OUT17/8734

**Moorebank Intermodal Terminal Stage 1 Early Works (SSD 5066 MOD 1)  
Comment on the Response to Submissions (RTS)**

**Figure 8.13 Northern rail access option - Indicative construction footprint, access and haulage**

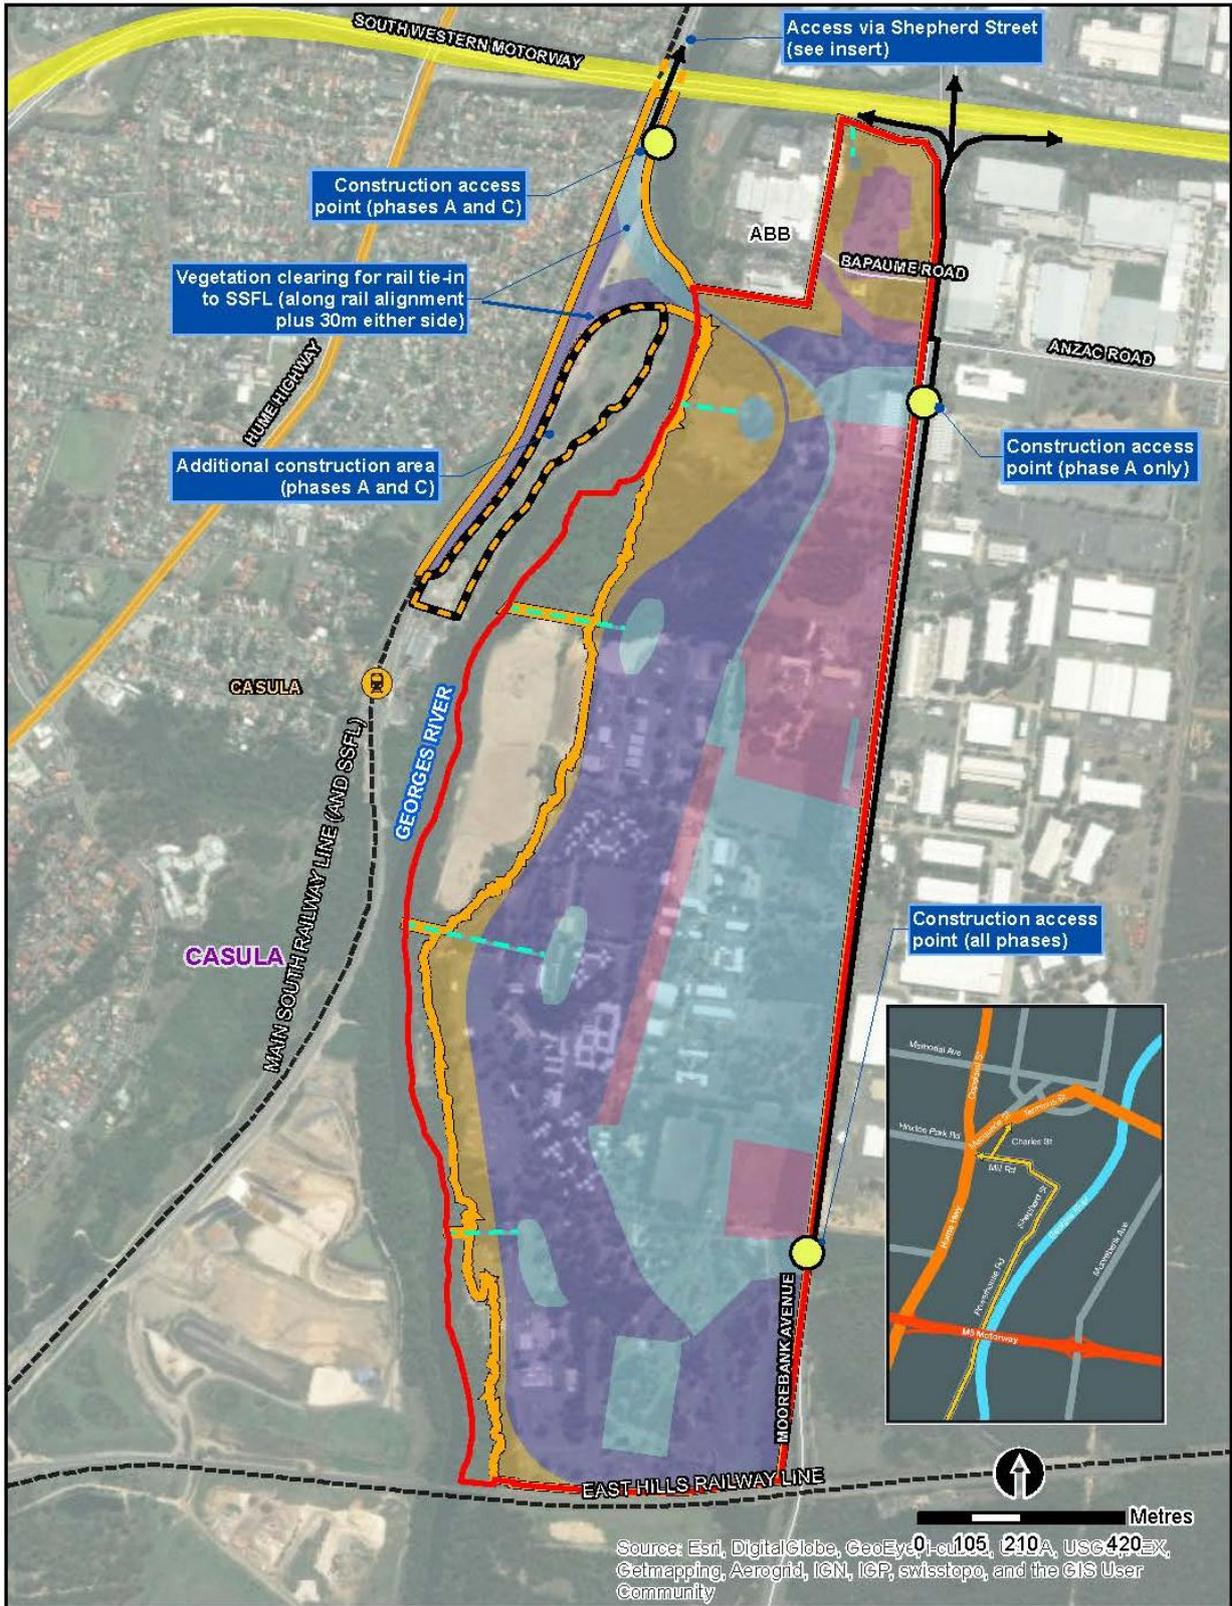
- The EA for the Concept Plan Modification indicated the Mod 1 proposal would not require works on waterfront land and the area of impact was outside the Georges River riparian corridor, however the RTS indicates the modification proposal has been amended and now requires two additional on-site detention basins to be located in the south western and northern portions of the site. The resulting gaps in the vegetation are expected to be significantly larger than those outlined in the original Concept Plan Environmental Impact Statement. The proponent should consider alternative options to the basin located in the south western portion of the site to reduce potential impacts to riparian connectivity.

- If the south western basin is necessary the proponent should ensure that the detailed design includes:
  - further detail and justification of the width of drainage channel outlets to be used during construction.

- investigate potential options to minimise the outlet width and the potential impacts on the river bank profile and riparian connectivity.
- The proponent should provide details on whether detention basin in the northern portion of the site is to discharge to Amiens Wetland and if so, the potential impact this could have on the hydrology of the wetland should be assessed.
